Recommendation Report for Planning Permission

REF NO: BR/80/17/PL

LOCATION: Land East of Pumping Station
High Croft Close
Bognor Regis

PROPOSAL: 1No. detached two bed bungalow. Resubmission of BR/163/16/PL

PROPOSED GROUND FLOOR PLAN
& SITE BLOCK PLAN.

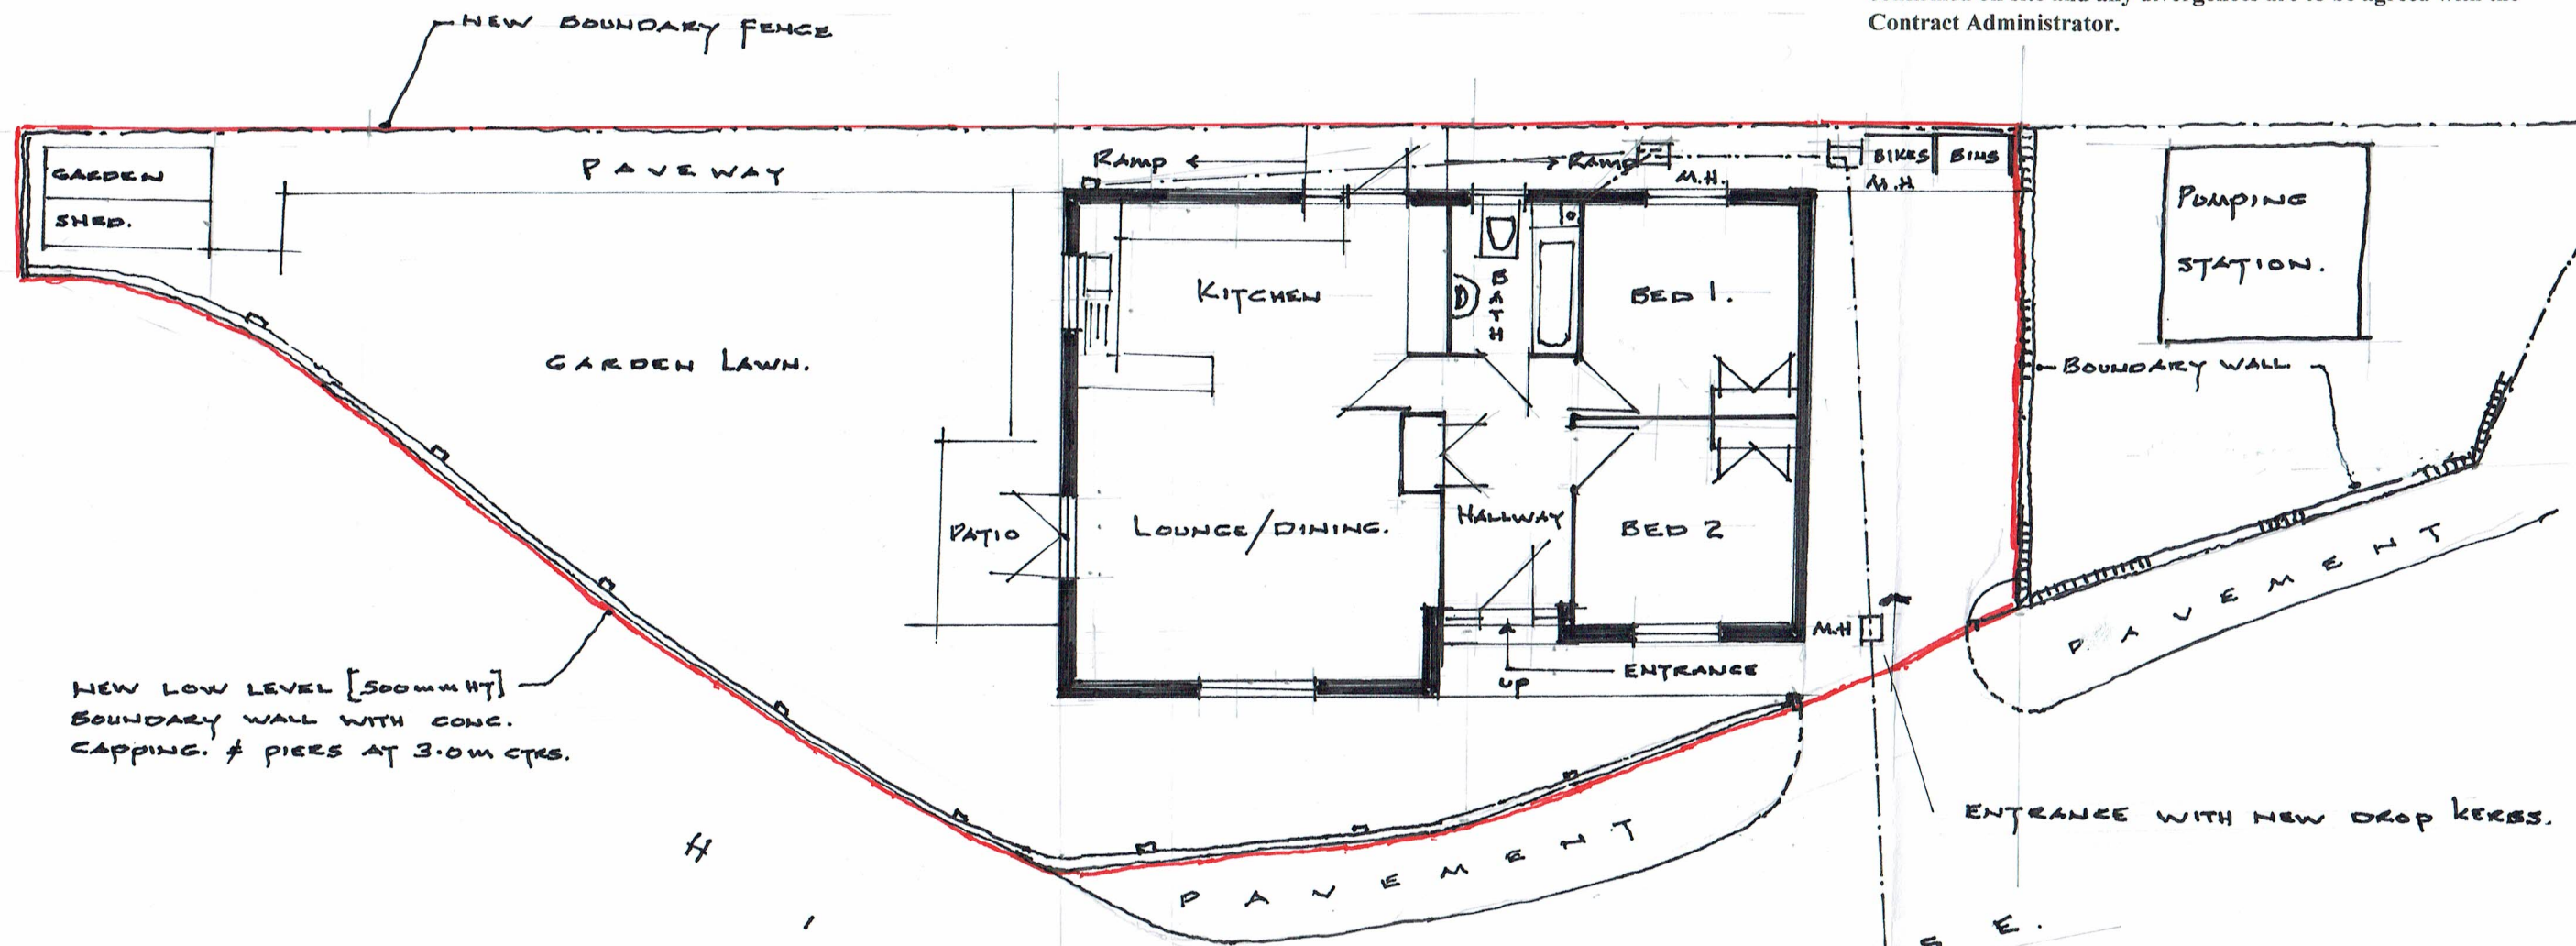
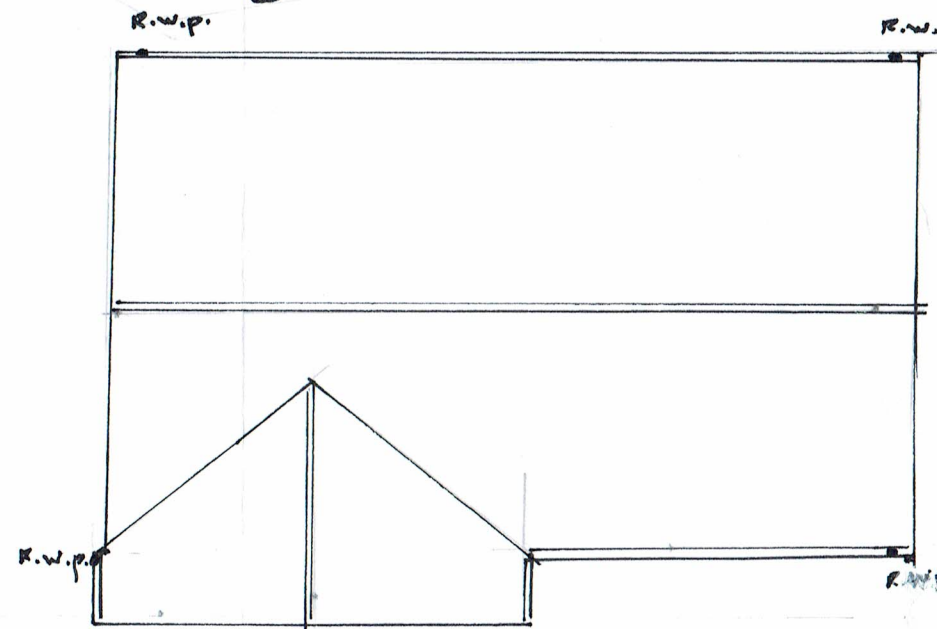
The application form states that off-street parking for up to 2 vehicles will be provided. A study of the block plan demonstrates that there appears to be insufficient space on-site for two vehicles to park. Whilst this does not necessarily pose a highway safety concern, there could be an amenity issue that the LPA may wish to consider. The dropped crossing must be implemented under licence to a specification obtained from WSCC Highways.

WSCC Highways advise that there appears to be insufficient space on-site for two vehicles to park. However, the size of the driveway area on the western side of the dwelling is at least 10.5m deep by 6m wide. This is excess of the standard dimensions of two parking spaces (4.8m by 2.4m) and therefore, it is considered that two cars could park within the site in a tandem arrangement.

The current proposal shows a 0.5m high wall around the plot. This would therefore afford no privacy to the proposed rear garden or to the east and north facing windows of the dwelling (which serve lounge/dining room, kitchen & a second bedroom). The future occupiers of the dwelling would therefore have limited privacy in their home and there would be pressure exerted on the Council in the future to allow a higher boundary.

The proposed dwelling requires a garden of 10m depth and 85m² in area. However, the rear garden as shown has a depth which varies between 4.5m and 12.5m and an area of only approximately 65m². The garden therefore falls around 20m² short of the Councils standards.

5070/2

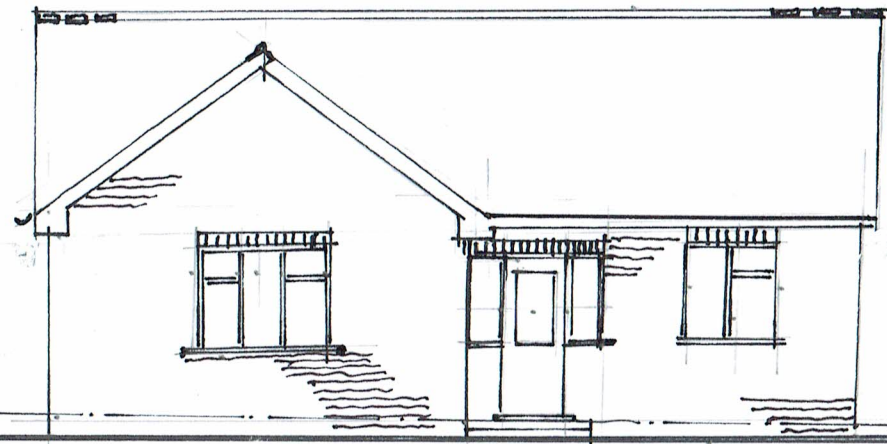
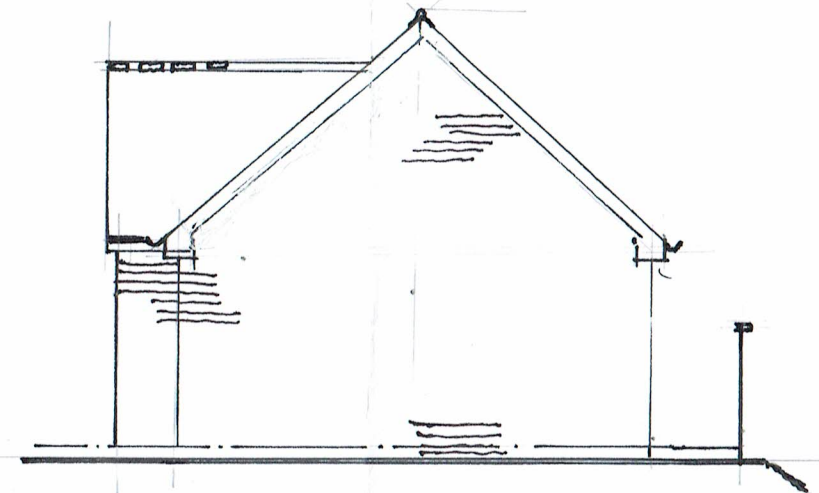
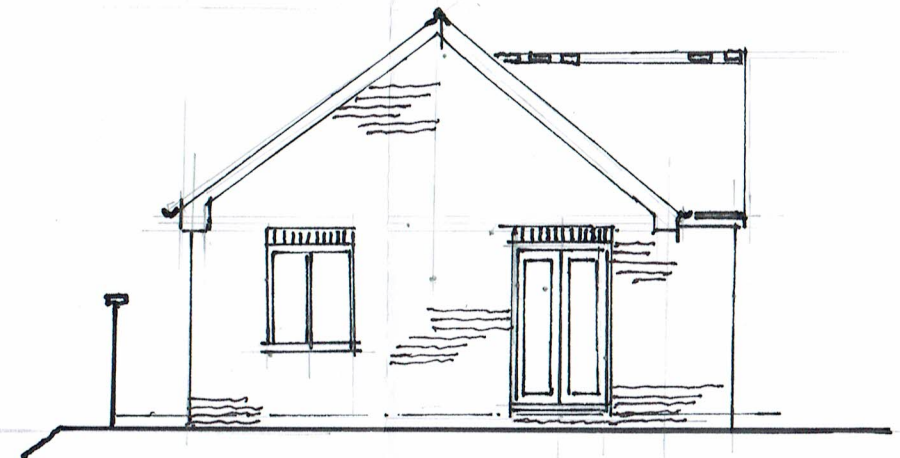
- (1) Flood Risk due to Flood Zone 3 designation;
- (2) Only enough parking for 1 car therefore potential for on-street parking to the detriment of refuse access/resident movements;
- (3) Small garden area;
- (4) Low boundary wall will result in a loss of privacy from east facing lounge windows & use of the new garden - the boundary treatment should be much higher;
- (5) Dwelling at risk from noise, odour, vibration from the pumping station;
- (6) Work required to flatten the site;
- (7) Impact on wildlife on the site boundary/within the allotments;
- (8) The plot is far too small;
- (9) Do room sizes meet the standards?; and
- (10) Inadequacies with the submission - (a) no indication of levels, (b) no dimensions shown between the bungalow & the boundaries, (c) No section/vertical heights shown, (d) No scale bars, (e) Drawing 5070/2 shows a varied roof pitch of between 36 & 42.

(10) Not all of these are strictly required but levels information has now been provided. It does appear to be the case that there are inconsistencies with the roof pitches. This will be brought to the applicants attention.

- 4 **INFORMATIVE:** The applicants attention is drawn to the comments of a local architect (received 12/04/17) who believes that the angles of the roof pitches shown on Drawing 5070/2 are not consistent.
